**Consultation Response from Mike Hibbert,
 KC Waste Strategy(Refuse & Recycling)**

2022/93938 Piazza Shopping Centre, New Street and Albion Street, Huddersfield, HD1 2TR

Change of use from A1 (business retail and storage) to C3 (residential) 34 studio flats at first and second floors and external alterations

Responding Ref: WPS 22-77

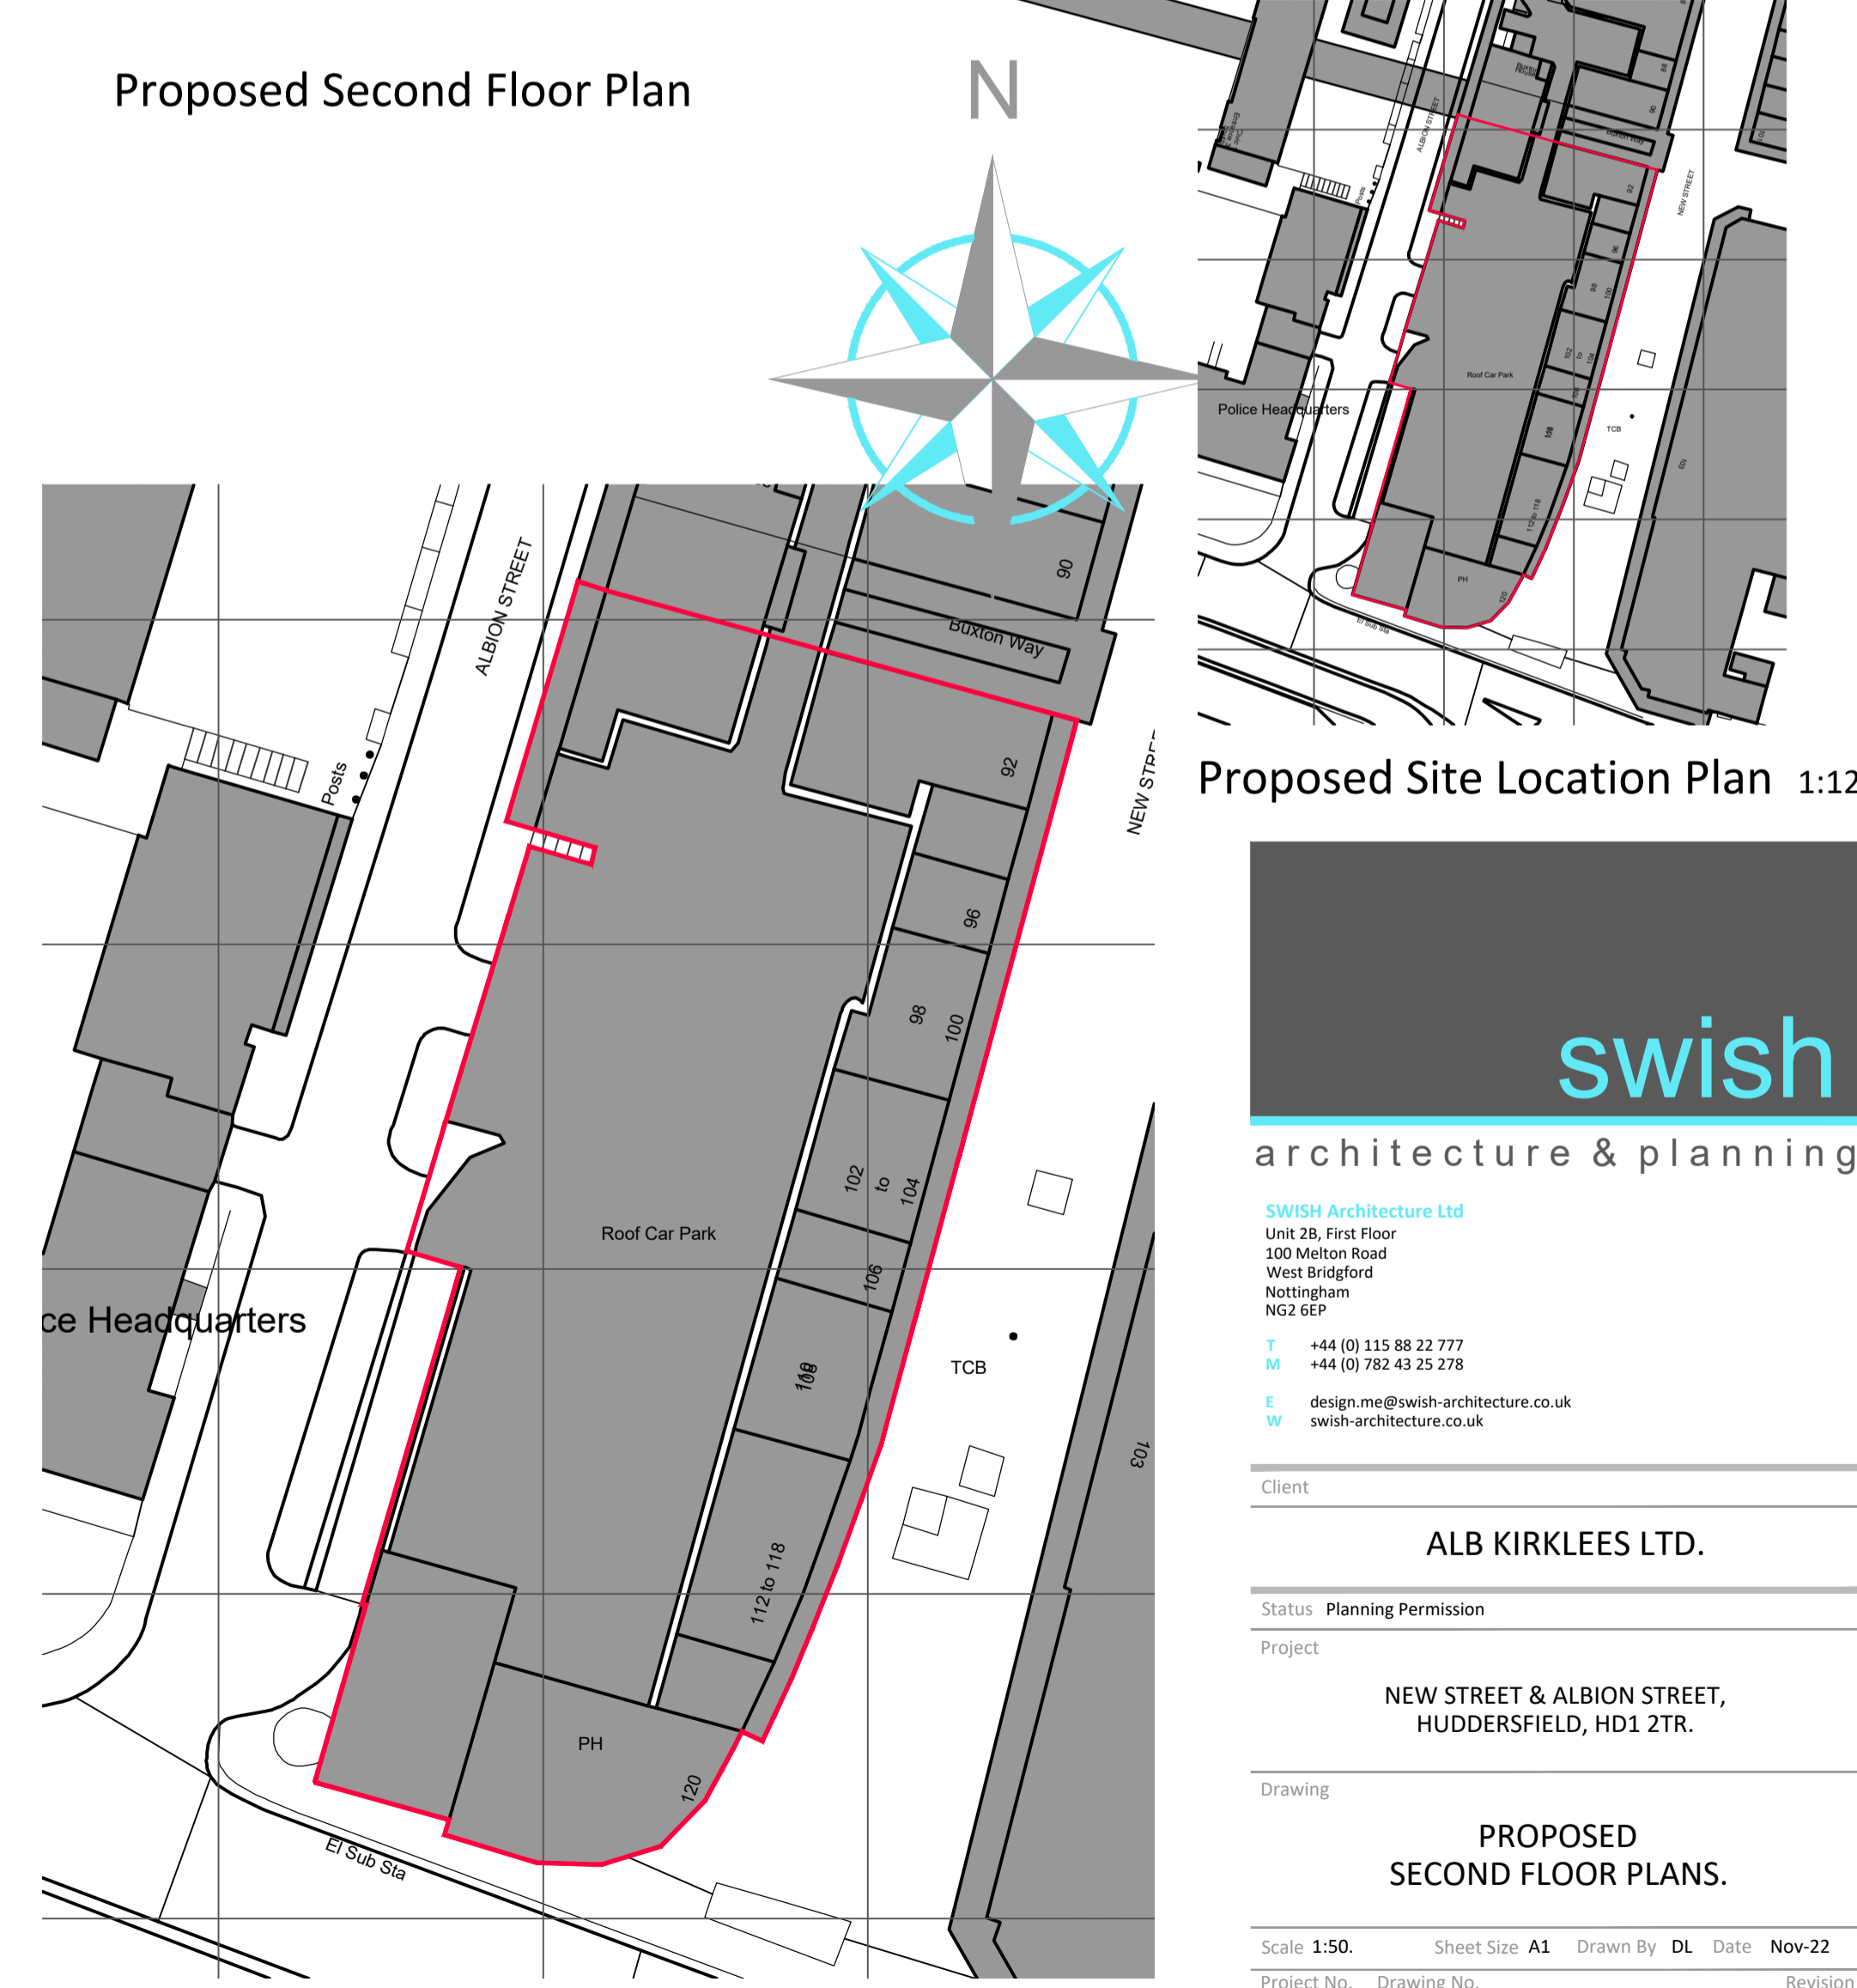
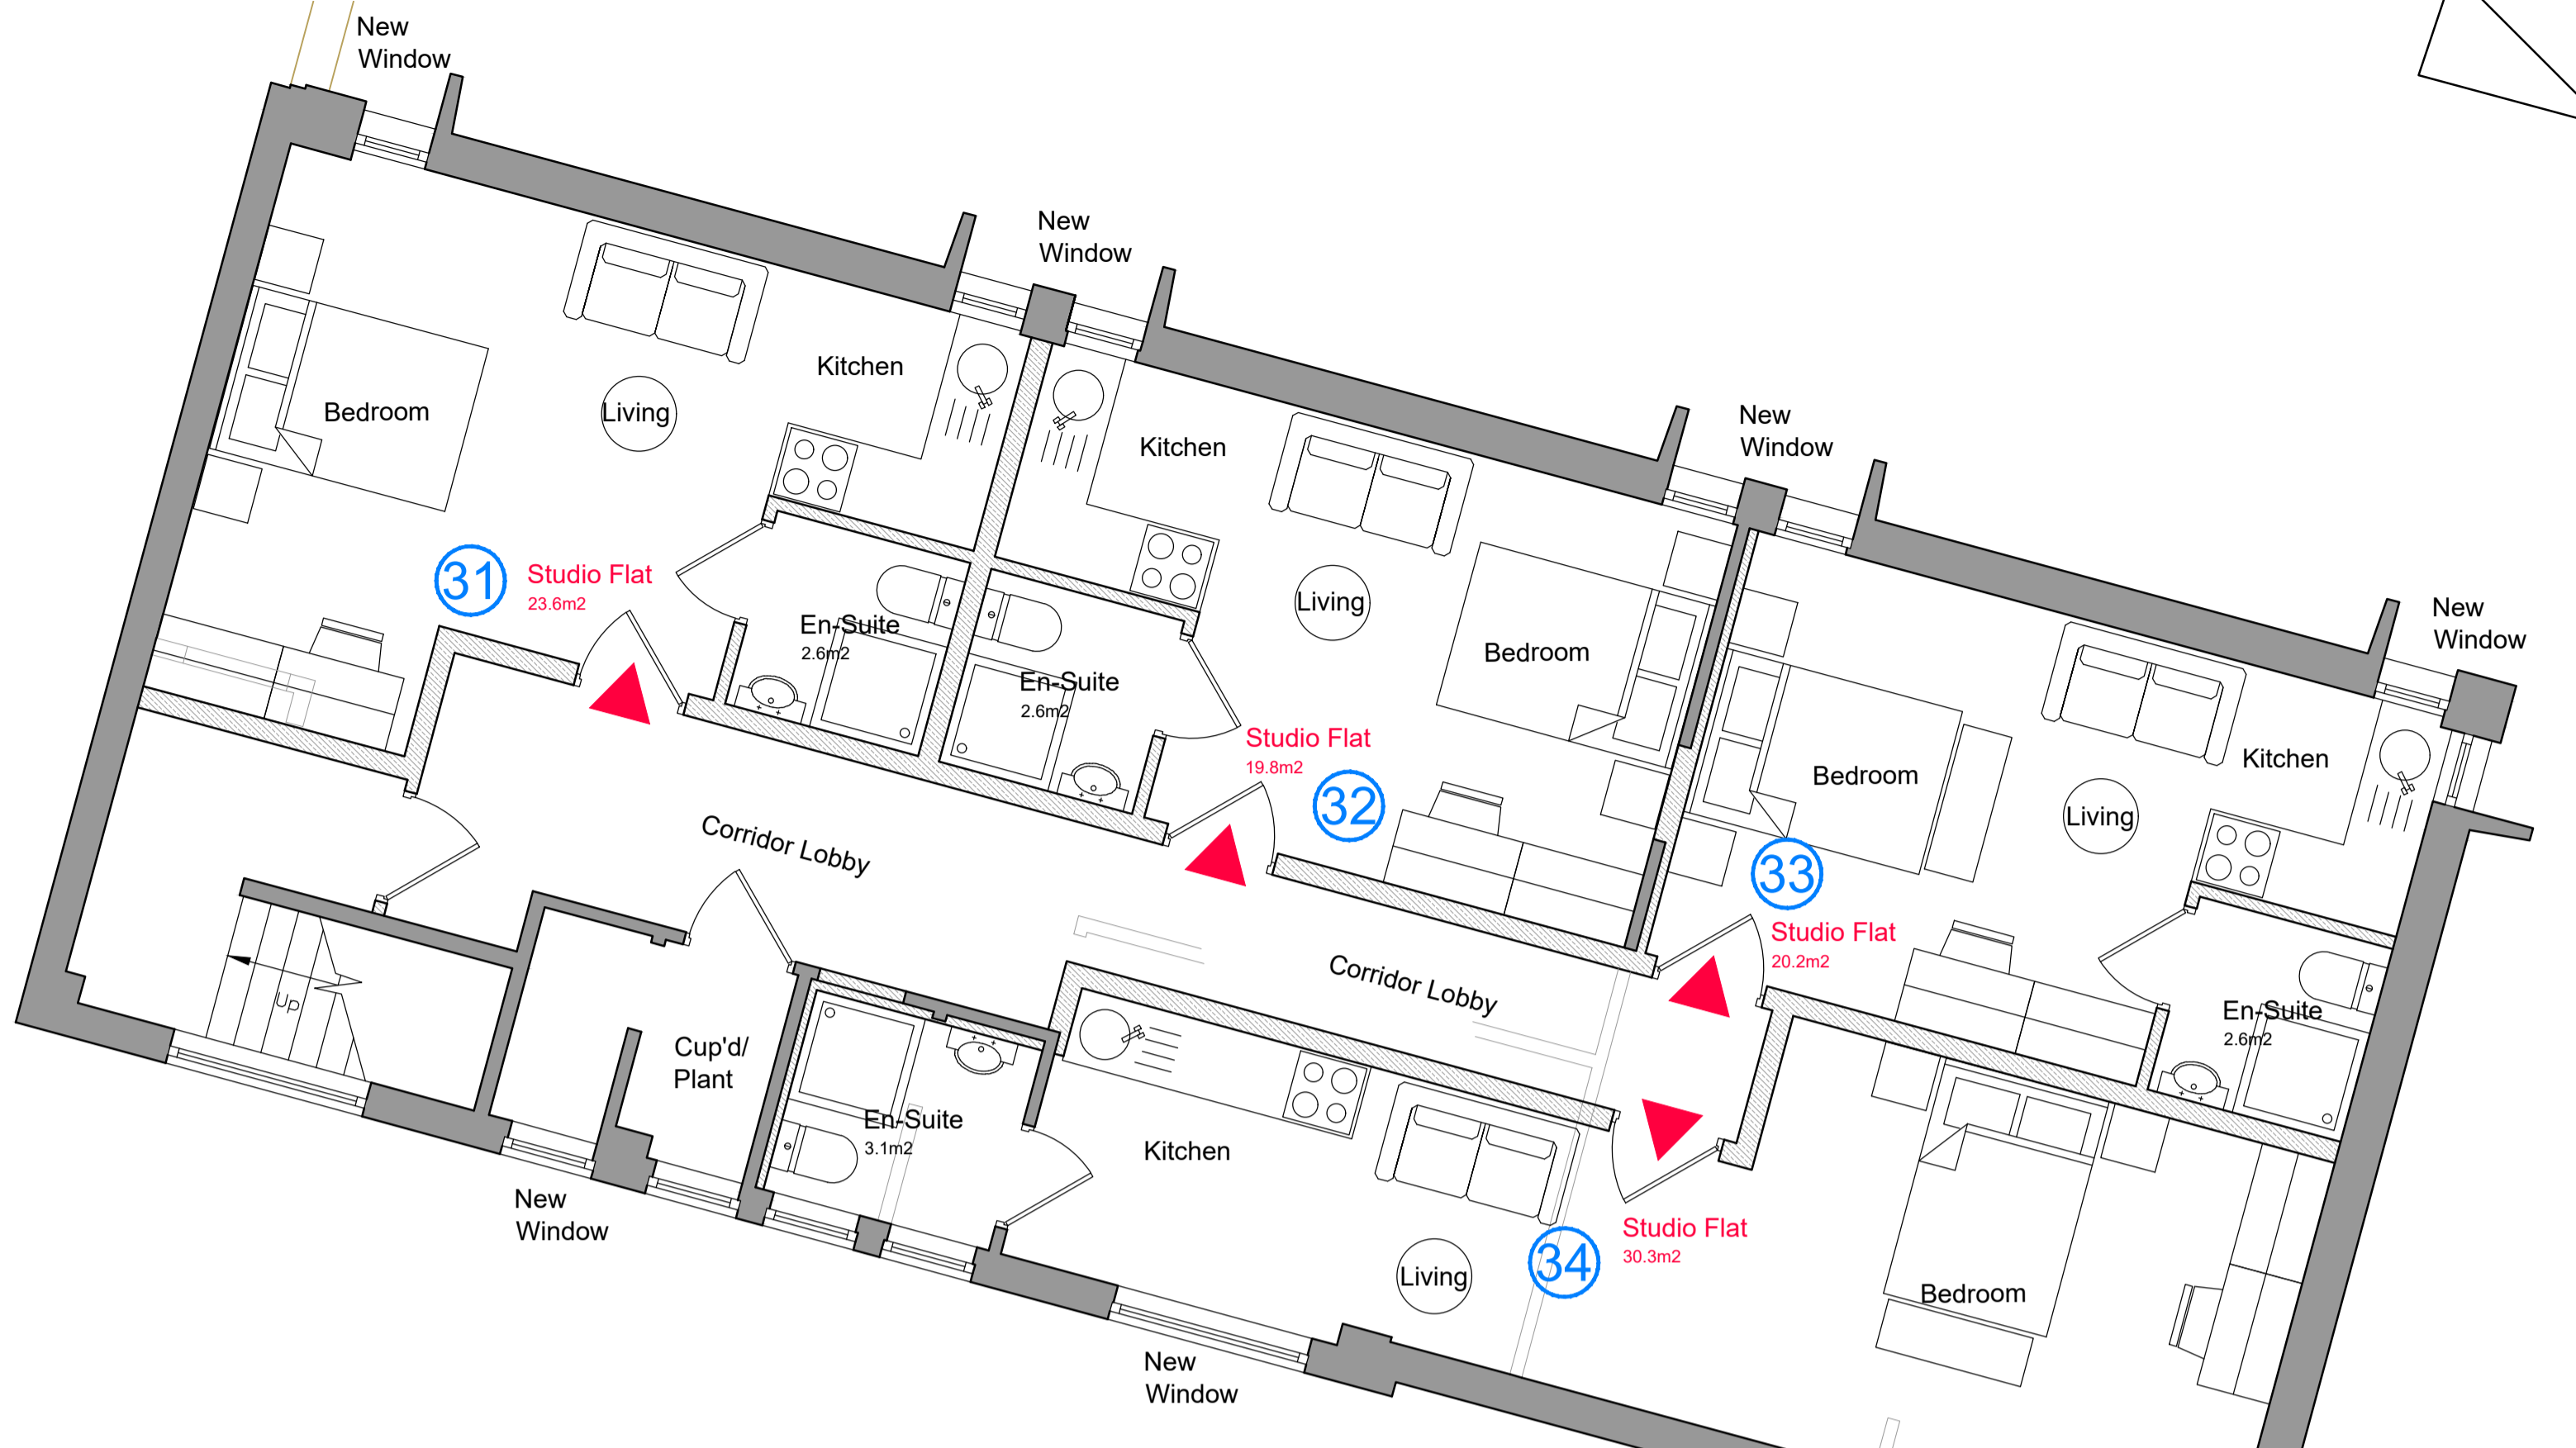
- Storage of wheeliebins on the pavement or roadway in New Street or Albion Street would not be acceptable.
- The applicant has not included any details on waste storage in the application form. The Design and Access statement dated 2/12/2022 states in Section 4.11 “Ample refuse storage is also provided for the proposal, with space allocated close to the proposed development to the internal courtyard of the site, as shown on the proposed site layout plan. Collections will be managed by a private collection company” and in Section 6.4 “Adequate refuse storage has been provided within the development to meet the needs of future residents for the lifetime of the development.” Despite reference to site plans proposed floor plan ref 22-60 .03 Rev A dated 7/12/2022 is not annotated to show details of a bin storage area.

- Guidance indicates the floor space for a 1100ltr wheeliebins is 1575mmx1190mm with space to manoeuvre the bins within the store so the bin store dimensions would depend on configuration within the store. There is no details of the exact location or design of the bin store provided. Additional information is required detailing waste storage, containers, capacity and design of the waste storage compound including,

- RCV Cleansing staff will not pull out the bins from the internal bin stores. There are no details of presentation points indicated on the plan of the site layout. Further information is requested on the location of presentation points and the arrangements in place to get the bins to presentation points.
